Rezoning Transportation Analysis

Petition Number: 2021-182

Date	Description
08-20-2021	First Review (KP)
09-28-2021	Second Review (BB)

REZONING SITE PLAN
AT PROPERTY KNOWN AS
1521 SHAMROCK DRIVE
LOT 6, BLOCK 5, DAVIS PARK
TAX # 093-098-16, DB 36233 PG 529, MB 3 PG 293
CITY OF CHARLOTTE, MECKLENBURG COUNTY, NC
FOR: BIRDCO INC

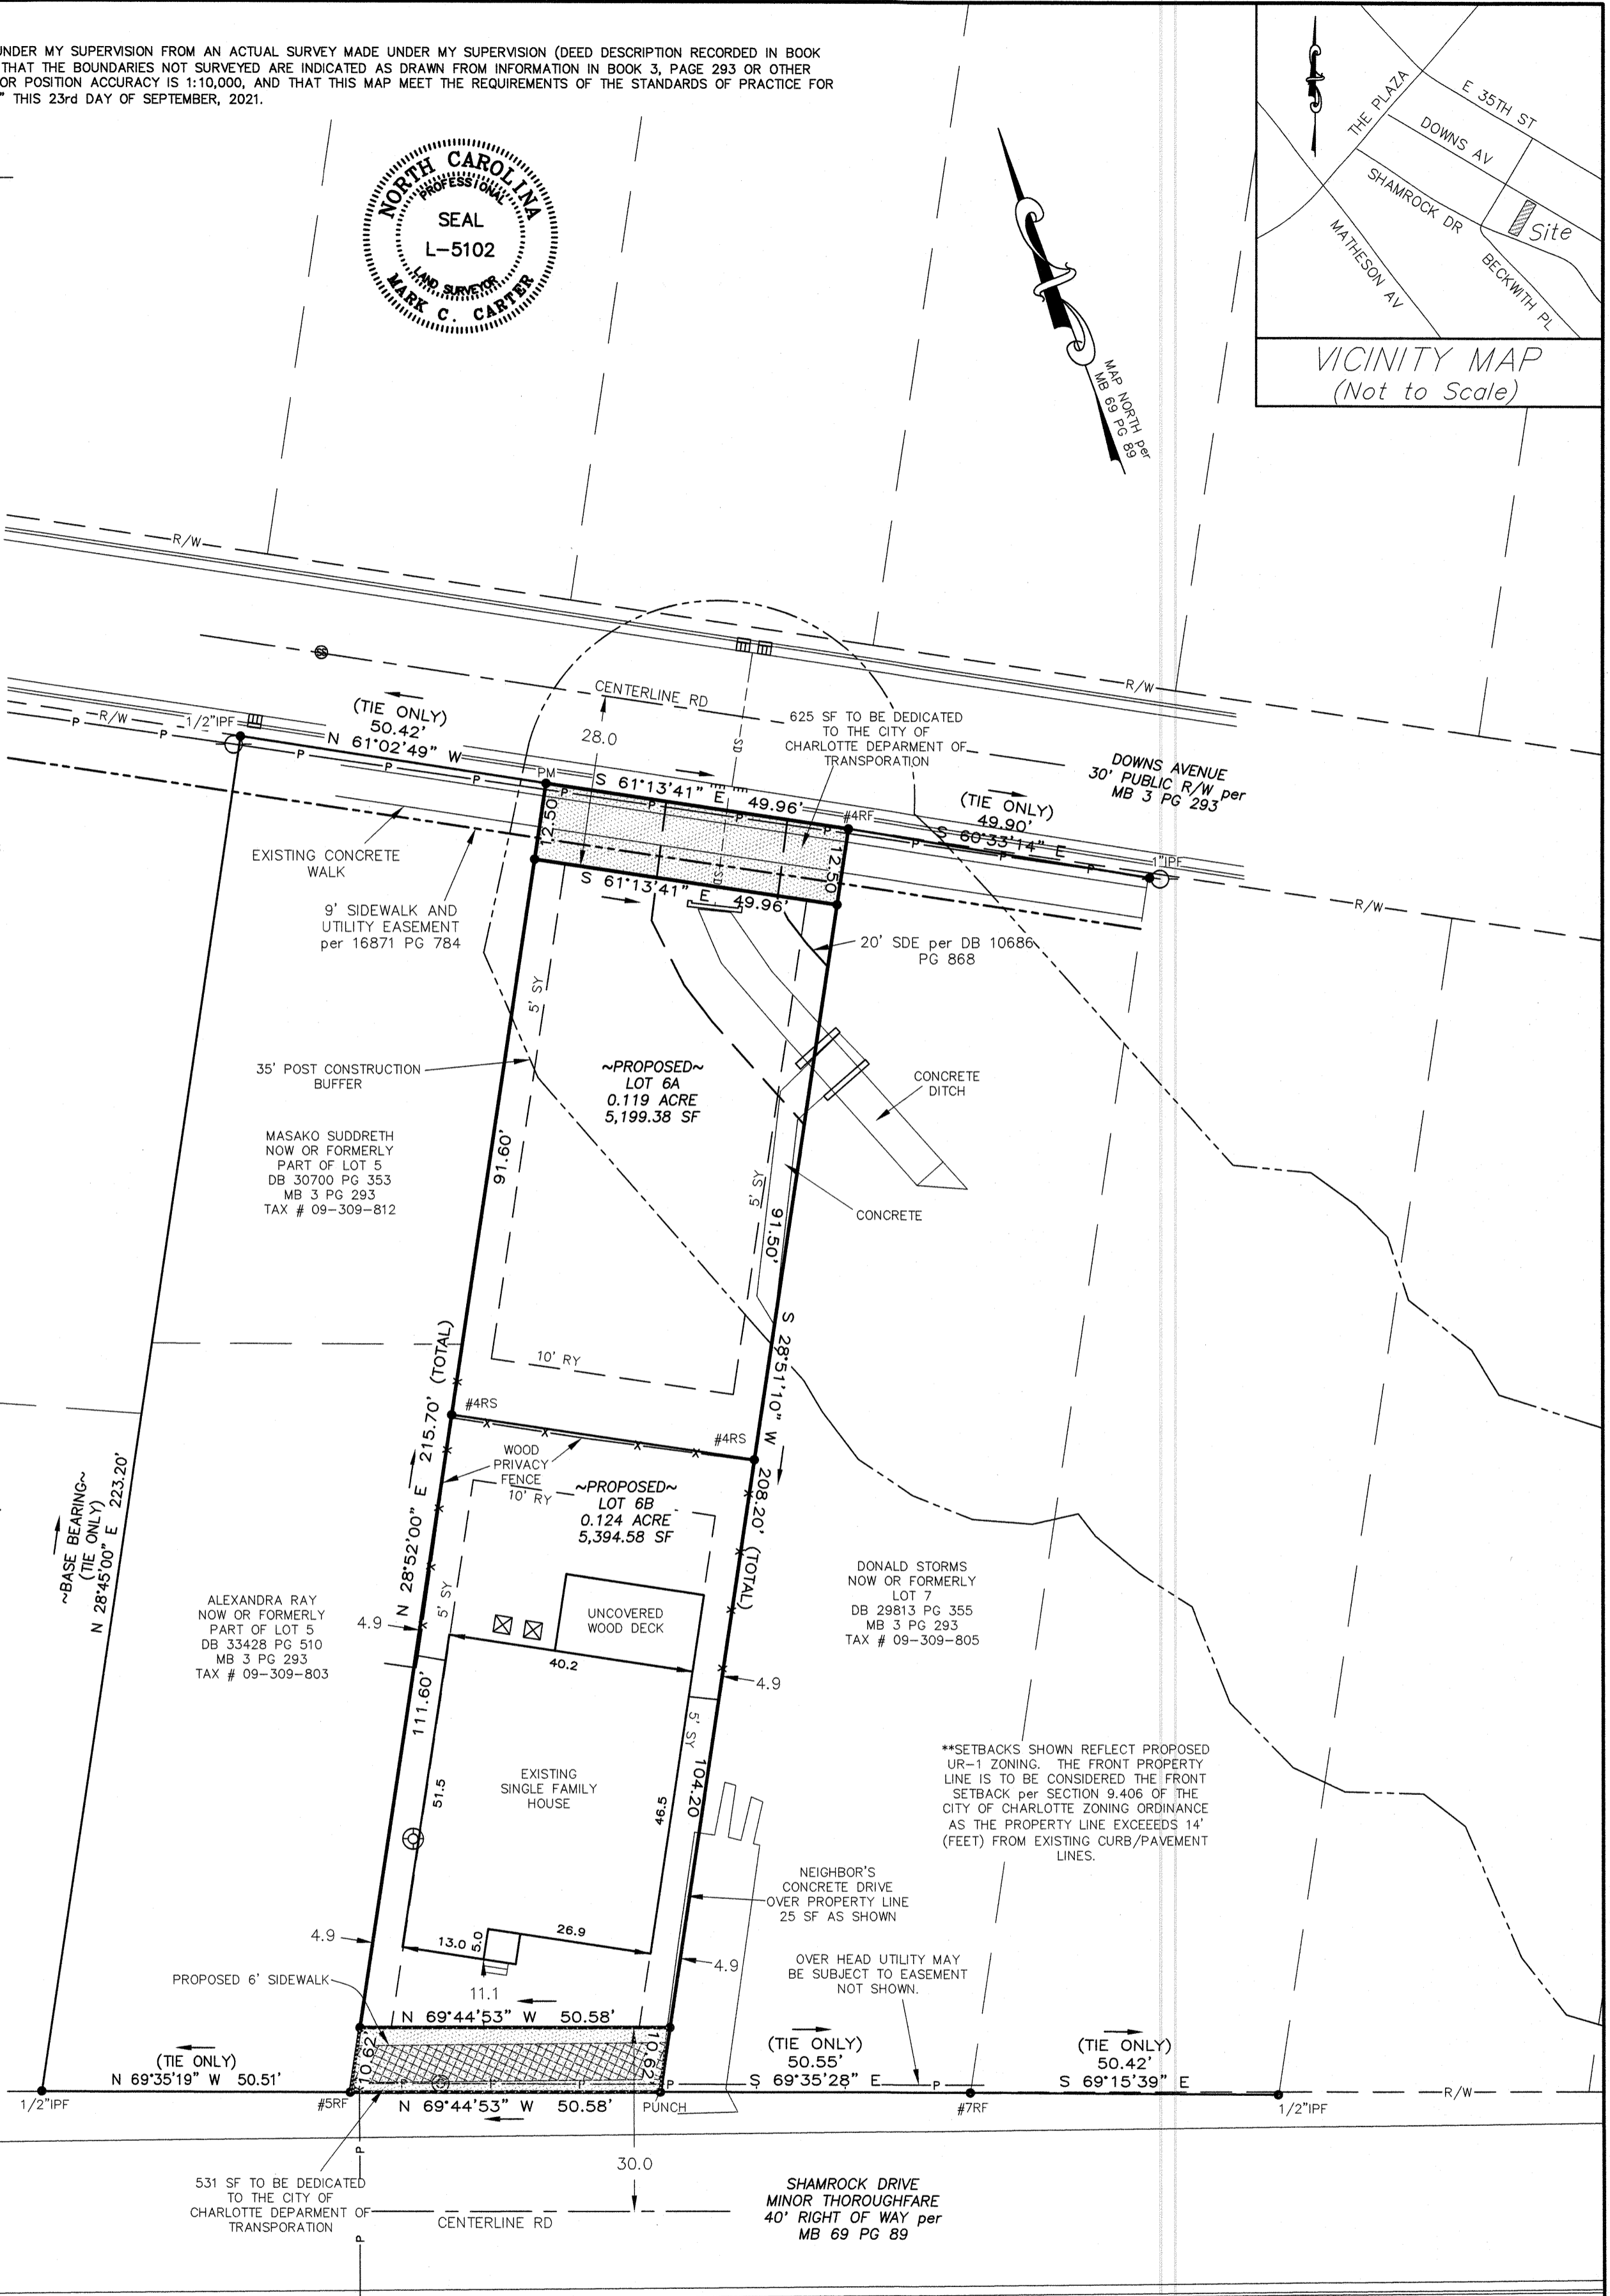
1. **Comment Rescinded (per revised site plan dated 09-23-21):** Transportation improvements consistent with adjacent properties and land use in area **Curb line:** The proposed zoning district has a setback measured from back of the existing or proposed future curb line.

a. **Downs Avenue:** The future location of the back of curb will be 13 feet from the existing centerline.

b. **Shamrock Avenue:** The future location of the back of curb will be 27 feet from the existing centerline.

Label and dimension the existing and future back of curb from the existing centerline of each road on the site plan.

a. **Downs Avenue:** Revise site plan and conditional note(s) to commit to dedicate 28-feet of right-of-way from the road centerline.

b. **Shamrock Avenue:** Revise site plan and conditional note(s) to commit to dedicate 45-feet of right-of-way from the road centerline.

The site plan shall label and dimension the right-of-way from the existing centerline of each road.

4. **Comment Rescinded (per revised site plan dated 09-23-21):** Transportation improvements consistent with adjacent properties and land use in area. A site plan note(s) specifying dedication and fee simple conveyance of all rights of way to the City and/or NCDOT before the site's first building certificate of occupancy is issued is needed. CDOT requests rights of way set at 2' behind back of sidewalk where feasible.
